CITY OF PORTLAND, MAINE  
DEVELOPMENT REVIEW APPLICATION  
PLANNING DEPARTMENT PROCESSING FORM

545 Auburn St.

RE: 545 Auburn Street (lot #2) – 382A-D-022 – R-2 Zone – application #05-0219

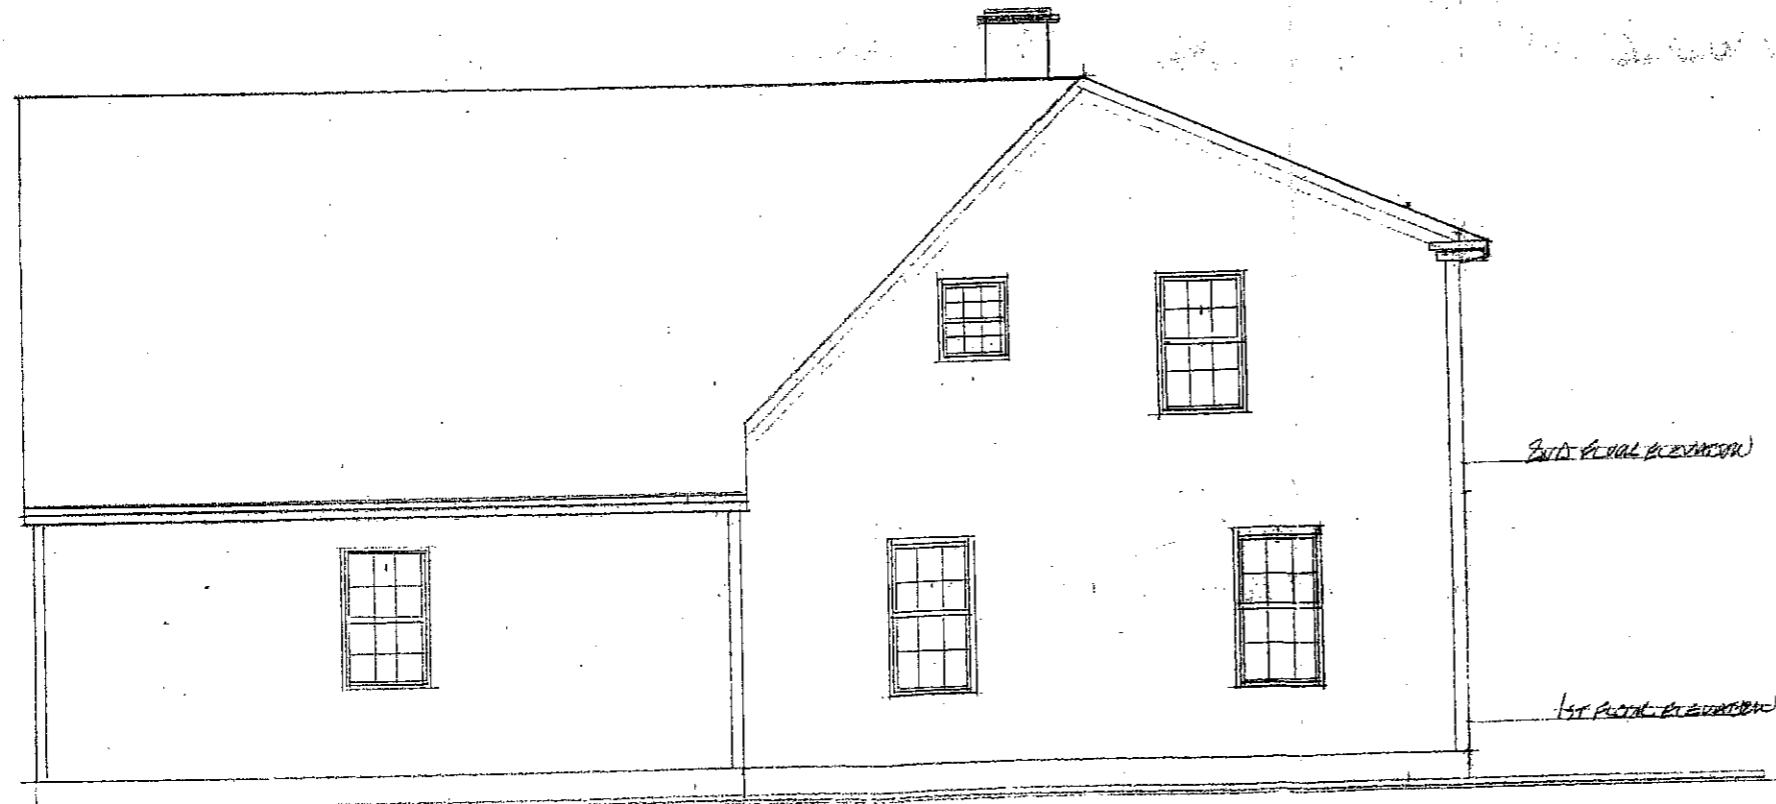
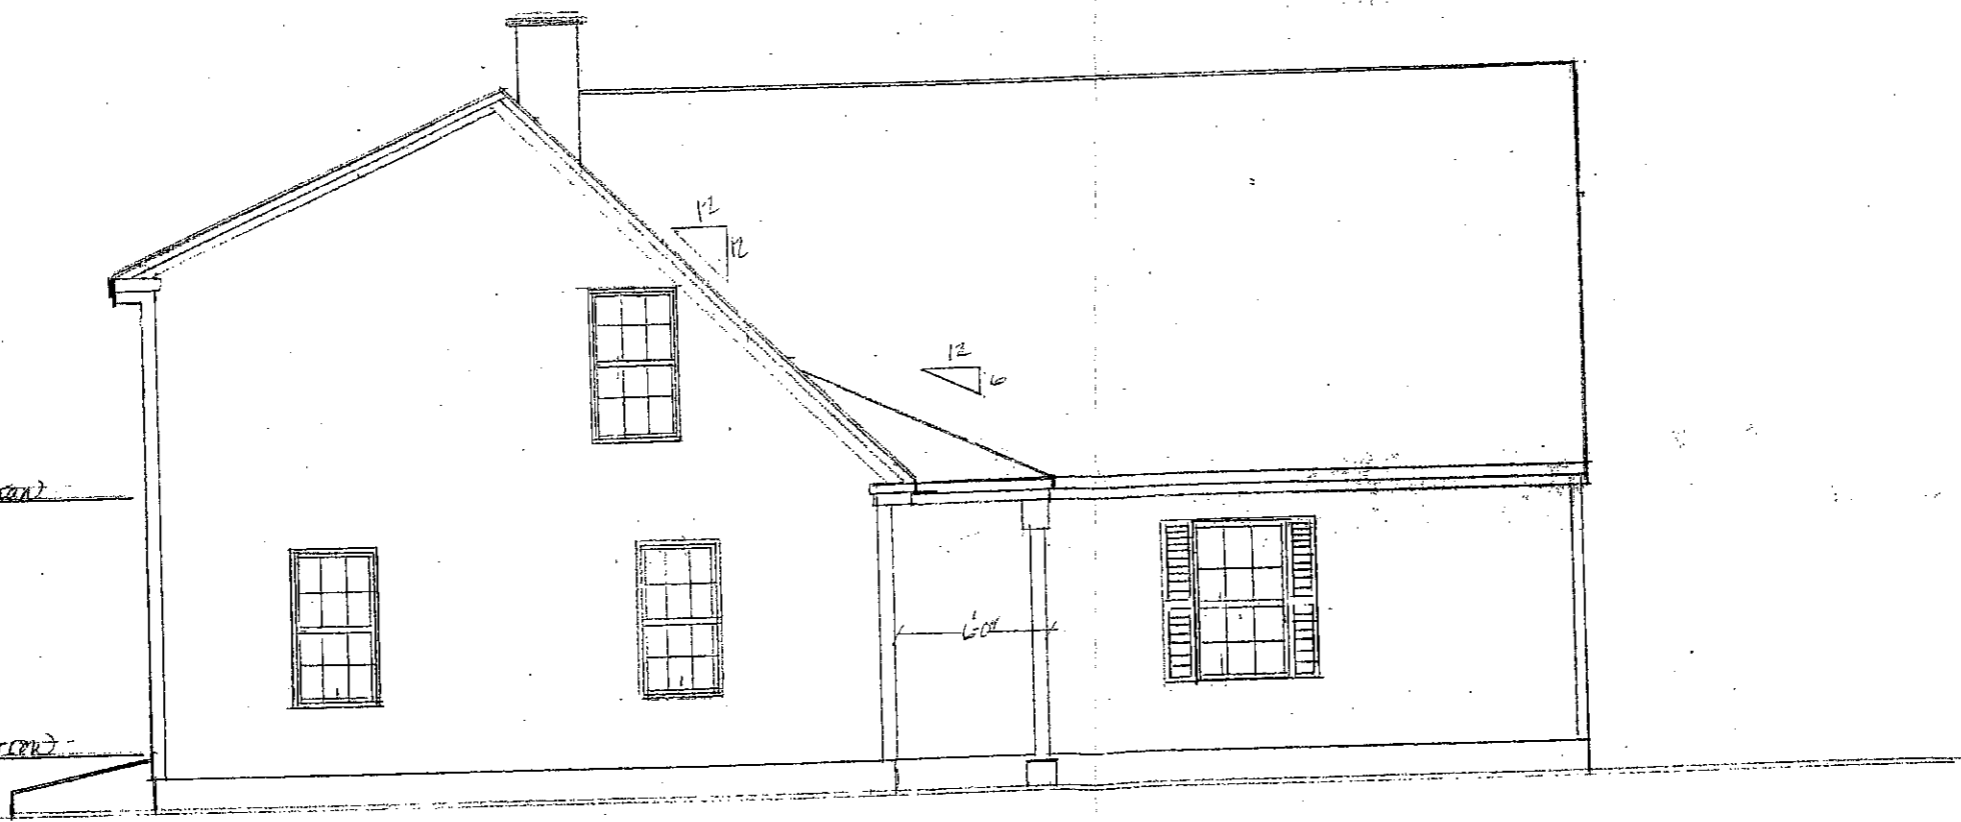
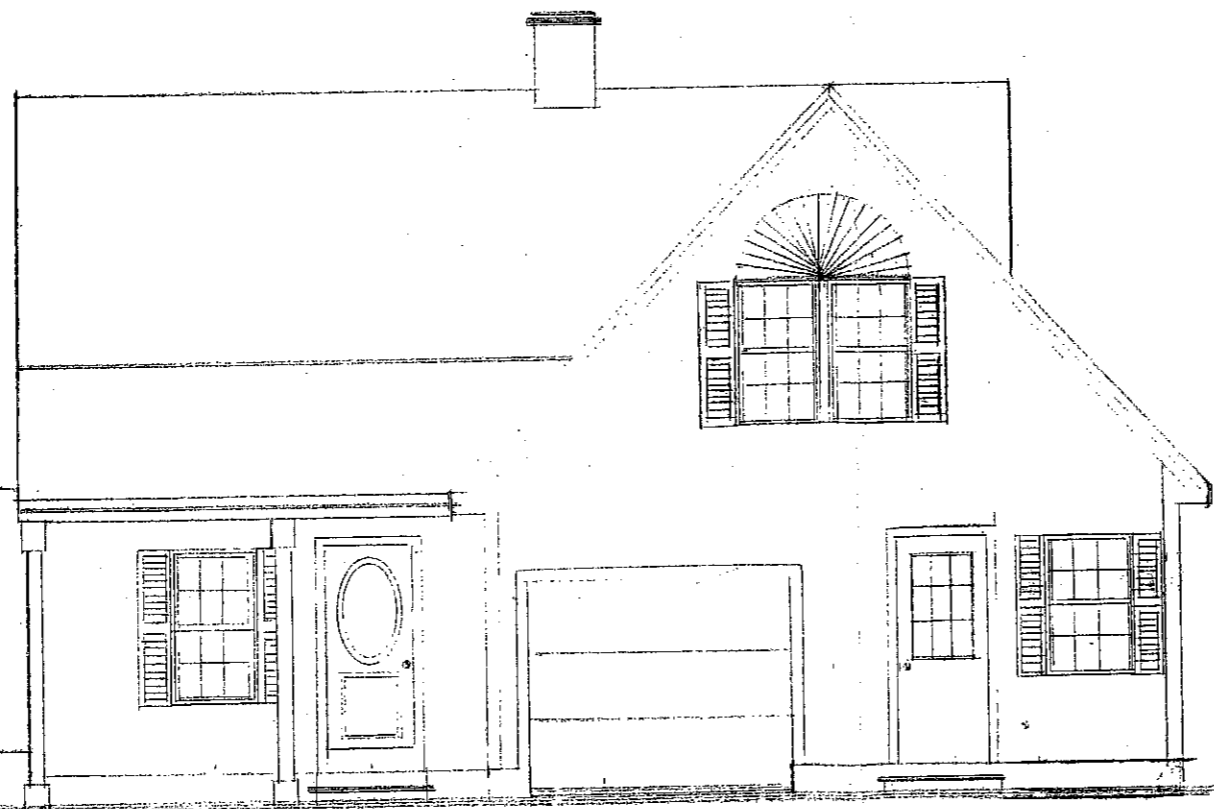
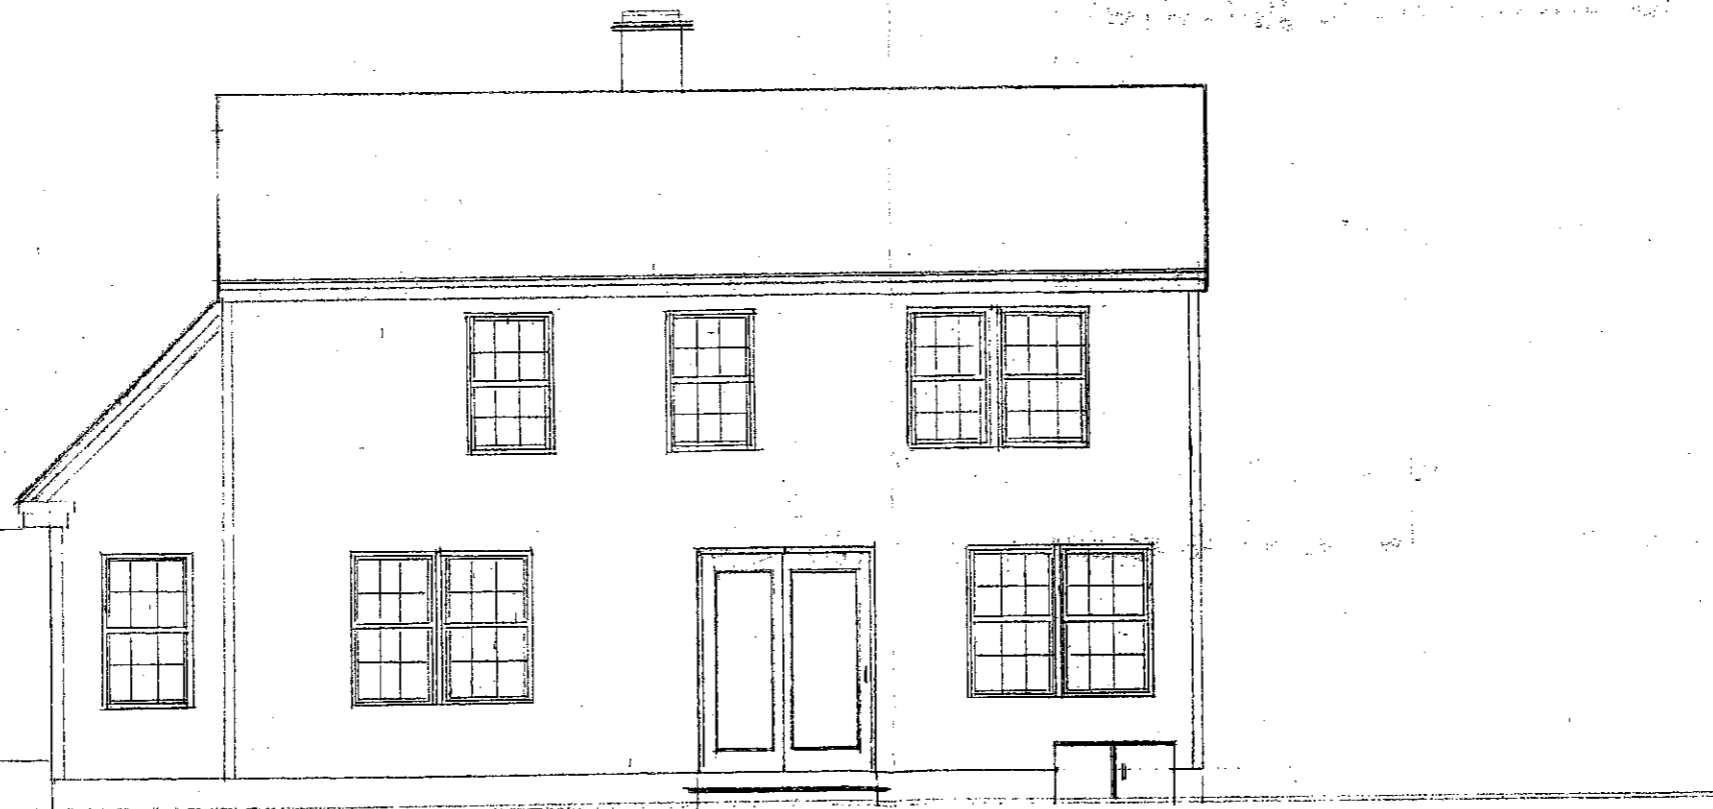
Your construction plans show a hair salon on the first floor. A hair salon is not an allowable principal use within the R-2 Zone. However, the City of Portland does allow for a home occupation within a dwelling unit. Before your new house permit can be issued, you must apply for a home occupation. I have included an application with this letter. Please fill it out as instructed and submit it to our front staff for processing. Your permit is on hold until such time that your home occupation permit application is reviewed and can be issued.

GRADING PLAN LOT 2

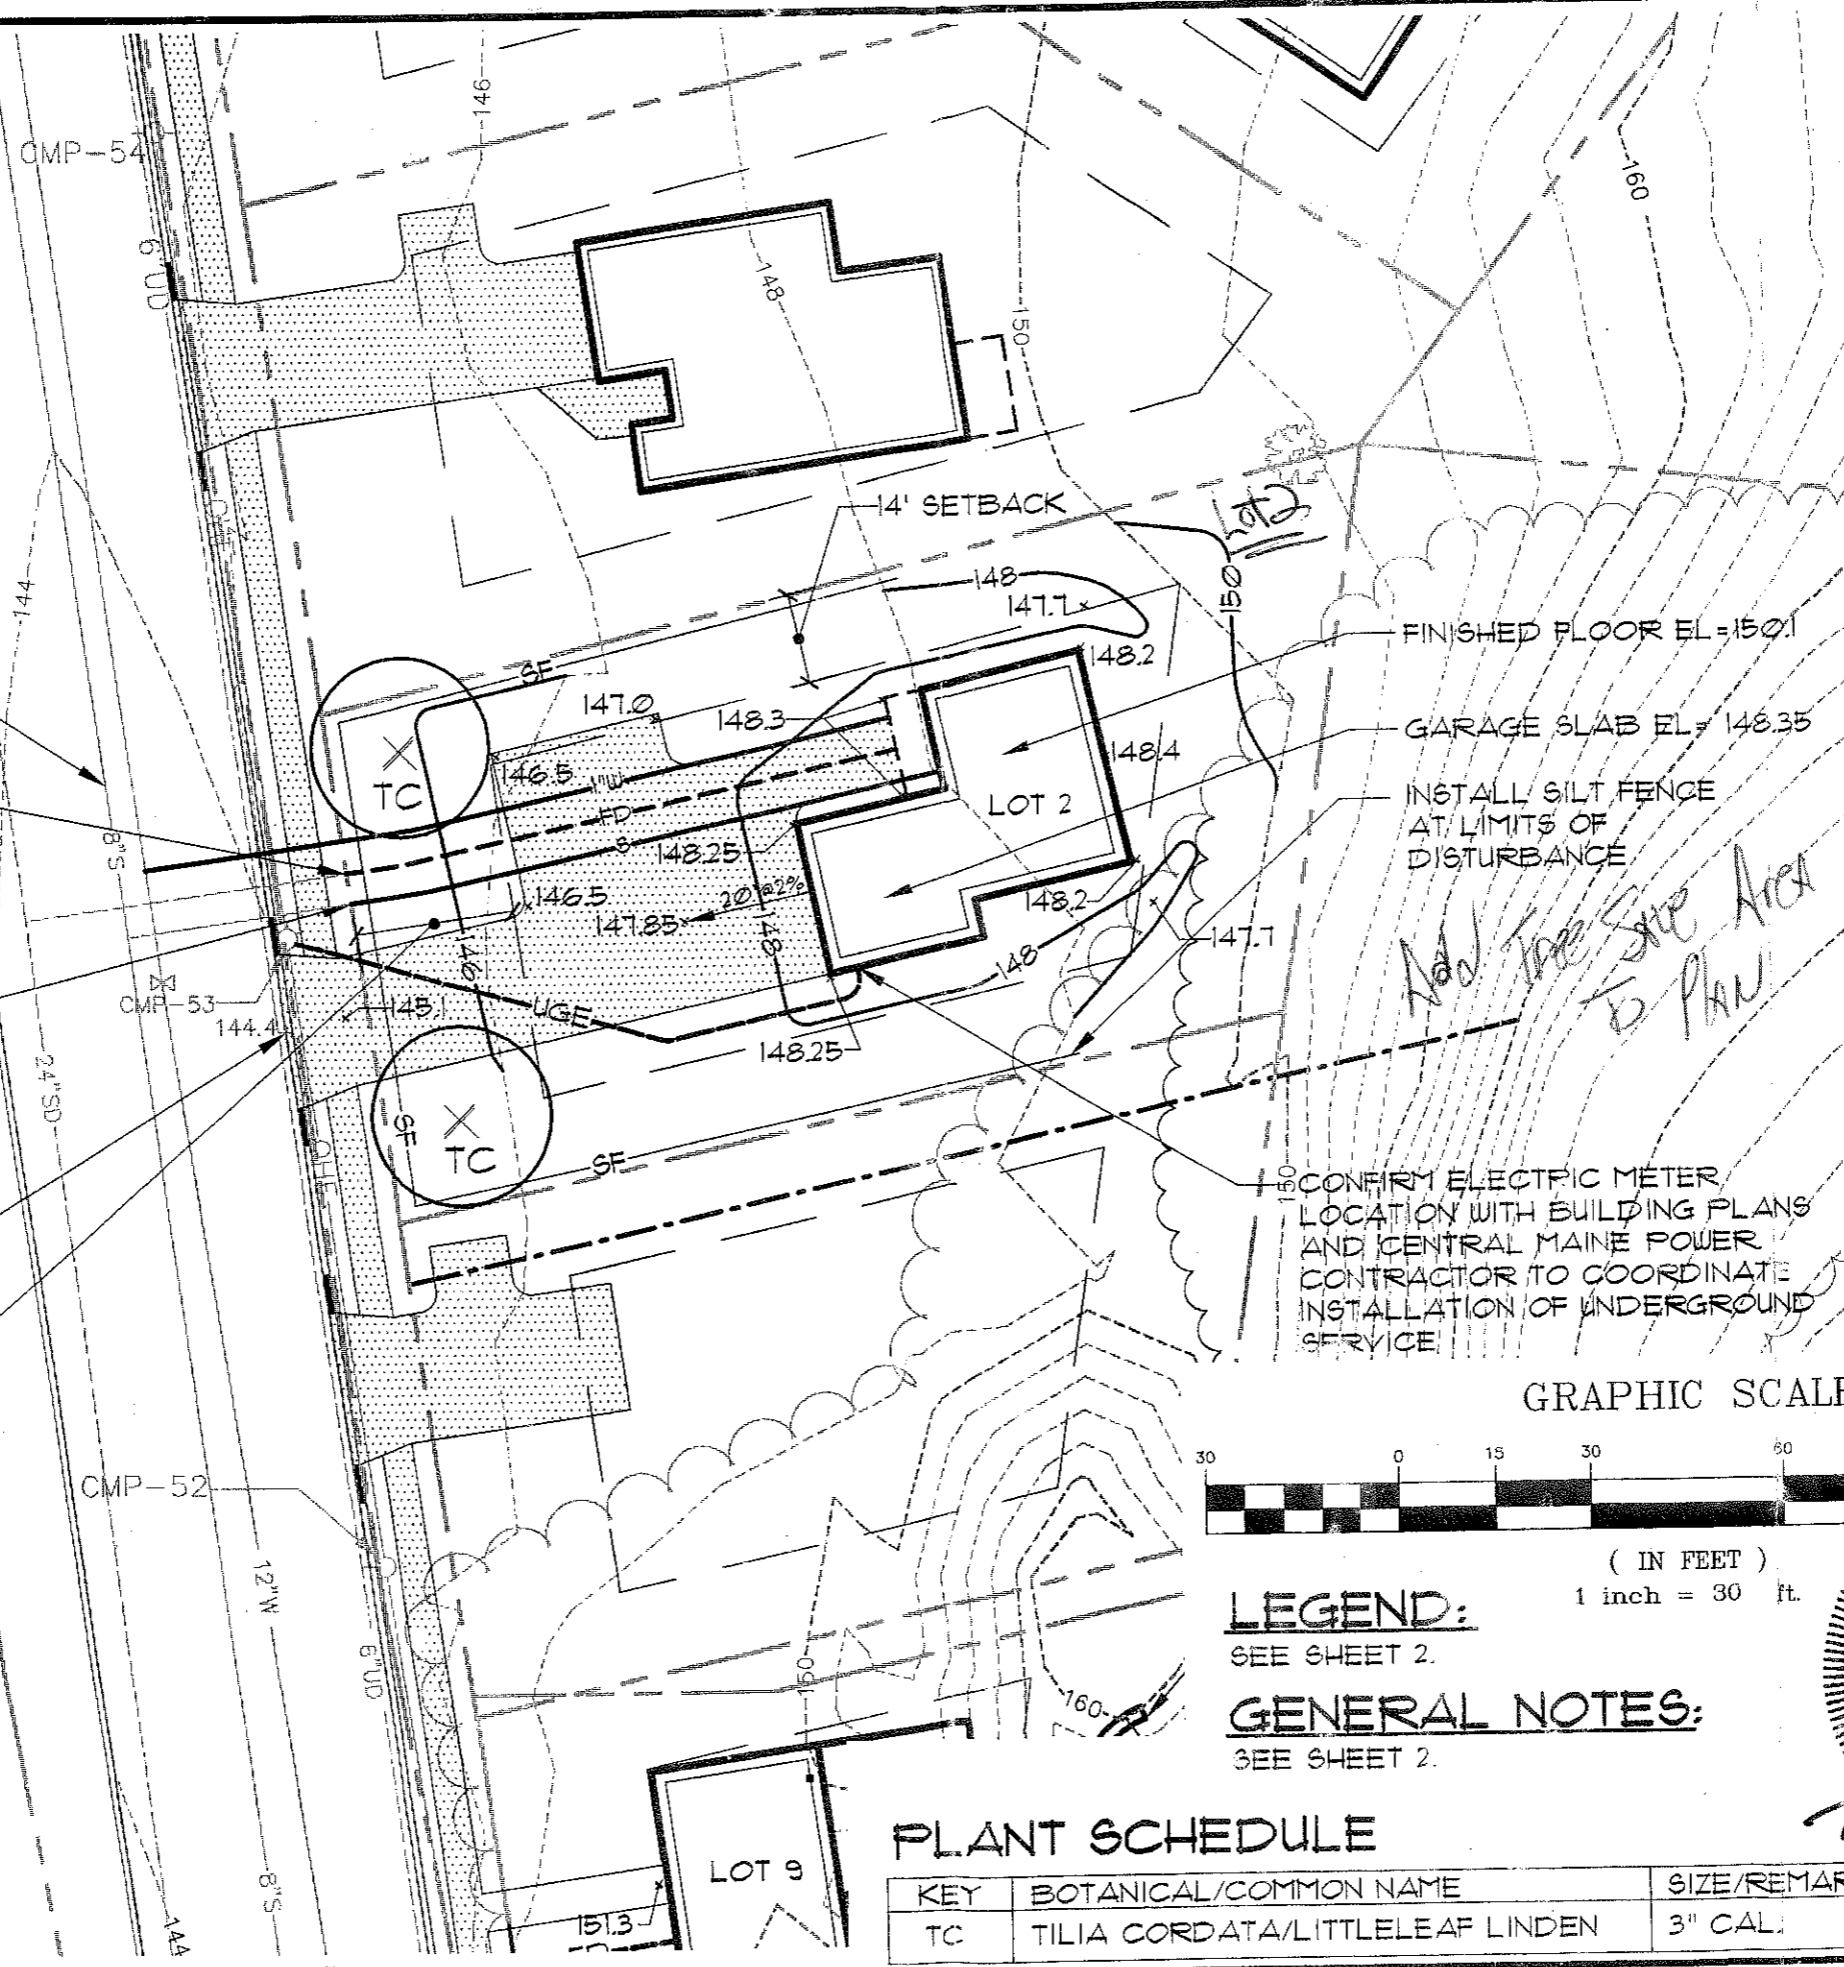
Add Tree-Site Info from  
Landscape Plan (SUS. Plans)  
to Site Plan.
